The Secretary  
NSW Department of Planning, Industry and Environment

25 August 2020

I refer to the Department's below email of 27 July 2020 regarding the notice of exhibition of the Environmental Impact Statement (EIS) for State Significant Development SSD-10446 at 275 Adams Road, Luddenham (Lot 3 DP 623799) for Luddenham Advanced Resource Recovery Centre (ARRC) developer advice of a revision to the proposed layout and design of the ARRC, with all waste and recycled product now proposed to be accepted, stored and despatched within a fully enclosed warehouse. Submissions need to be made to the Department by 26 August 2020.

Figure 7: Method of Supply Diagram

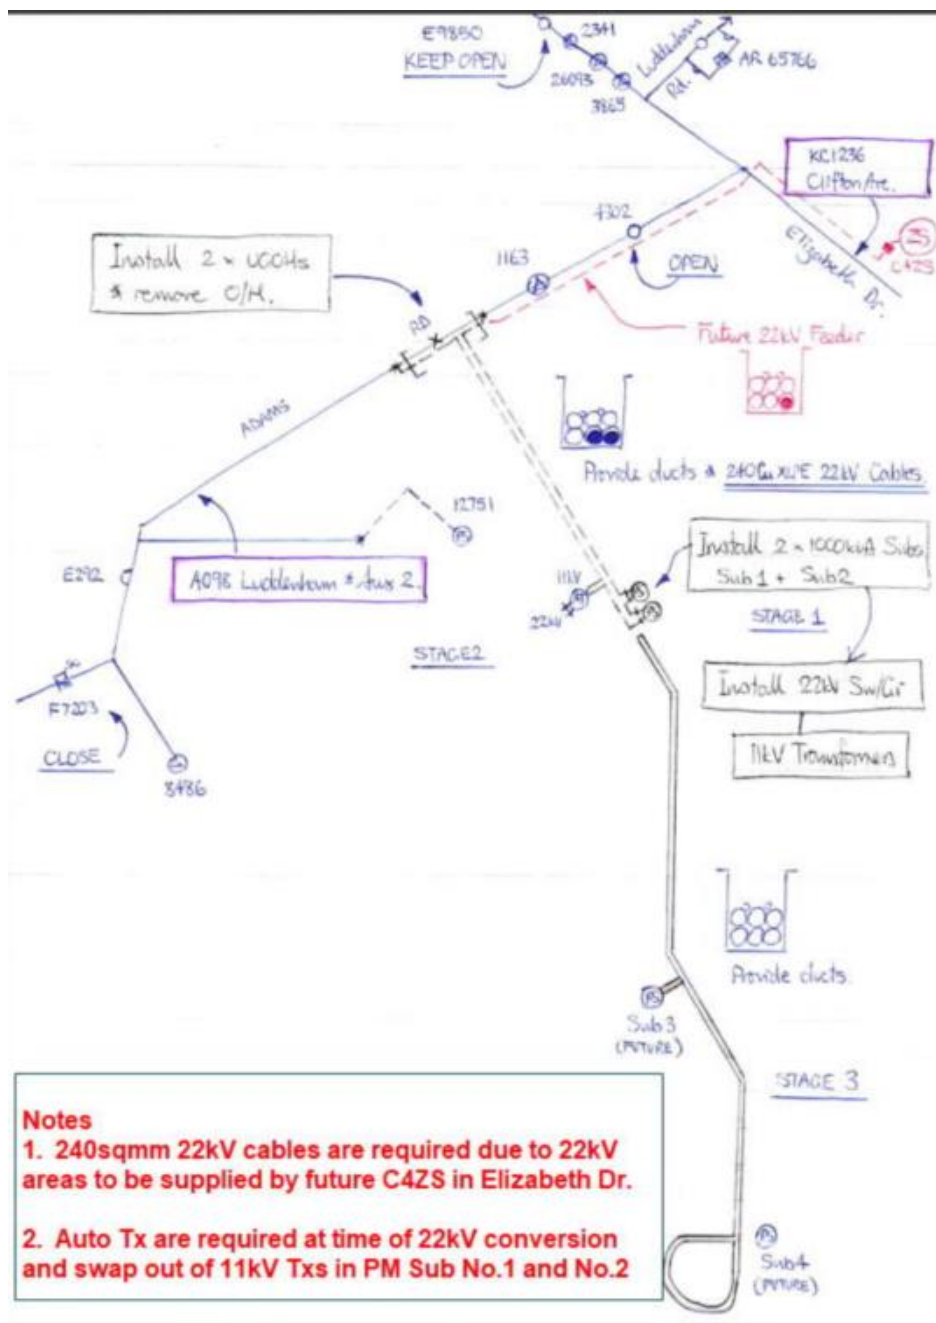
Endeavour Energy has noted that the Servicing Strategy Report includes Endeavour Energy's response to Technical Review Request (Endeavour Energy Ref: ENL3756 – 2014/02306/001) dated 16 June 2020. Accordingly the applicant should continue through the application for connection of load process with Endeavour Energy's Network Connections Branch who are responsible for managing the conditions of supply with the applicant and their Accredited Service Provider (ASP). Endeavour Energy's Network Connections Branch can be contacted via Head Office enquiries on telephone: 133 718 or (02) 9853 6666 from 9am - 4:30pm.
